Drainage Addendum

Site: Land to the North of Arundel Road, Fontwell, West Sussex BN18 OSF

Client: Harlequin Developments

Date: August 2026

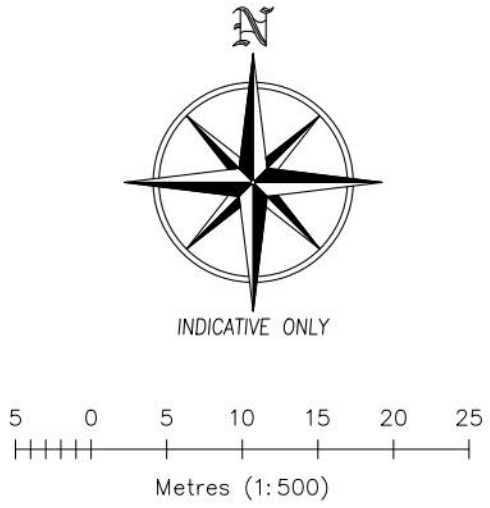
"Infiltration is not being used to drain the site, due to the groundwater levels. As mentioned, several times, all references to an "infiltration basin" shall be removed from all drawings, as this does not reflect the function of the basin. In the Contributing Areas Plan, reference is still made to an "infiltration basin"."

The infiltration basin is still included in the Contributing Areas plan.

In the Contributing Areas Plan, reference is still made to an “infiltration basin”.

- 1.2.2 There is no reference to an infiltration basin on the contributing areas plan reference 33186-D-01 Rev P3. A copy of the latest plan is shown in **Appendix B**.
